Please ask for: Ms Iqraa Malik
Email: iqraa.malik@terraquest.co.uk
Telephone: 0121 234 1390
Our Ref: LU/267/21/HH
Your Ref:
Date: 2nd September 2021

Application for Planning Permission for Works or Extension to a Dwelling

Development: Erection of single storey side extension, single storey side porch extension and alterations to fenestration following the demolition of existing side extension
Location: 21 East Ham Road Littlehampton BN17 7AW

SITE PLAN
PROPOSED
1:500 @ A3

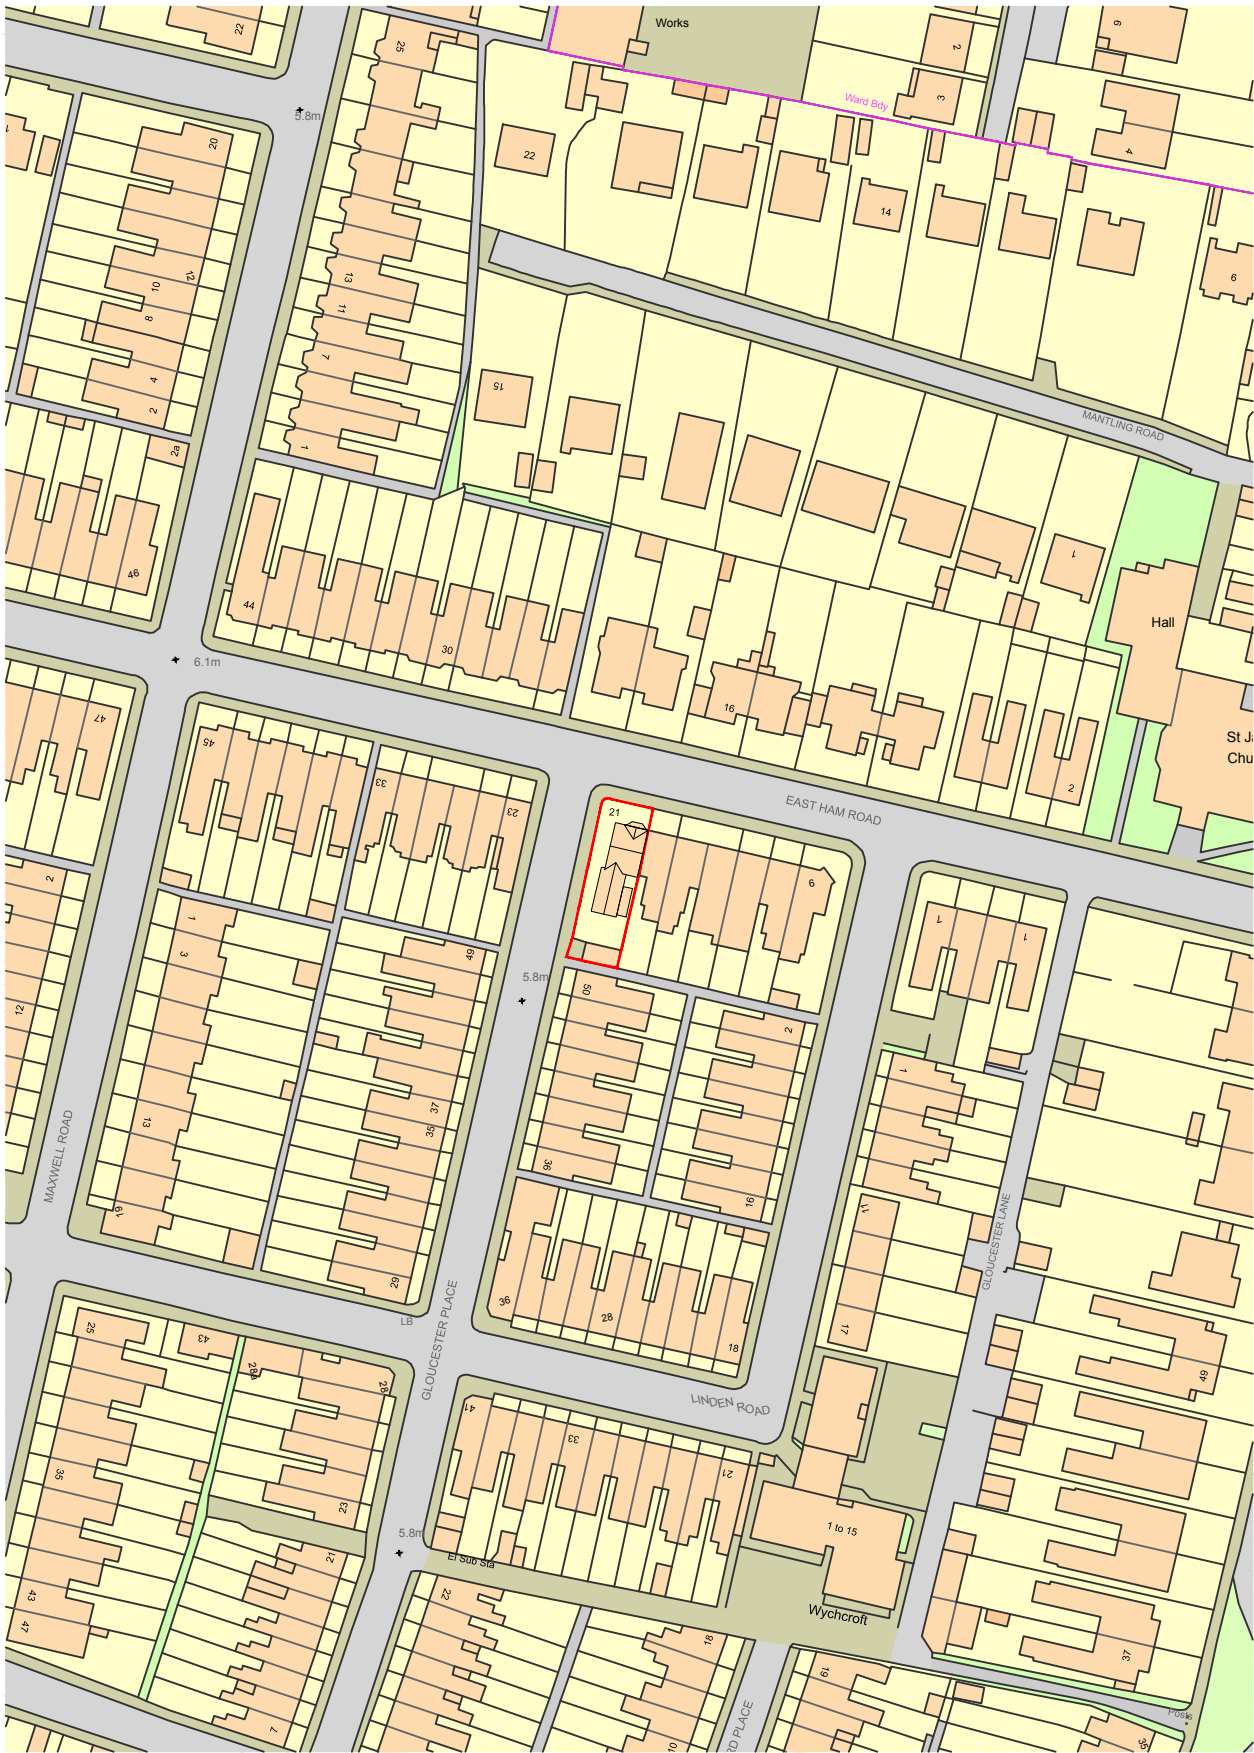
Block Plan

You are required to have dimensions from the proposed extension(s) to all site boundaries. Please amend.
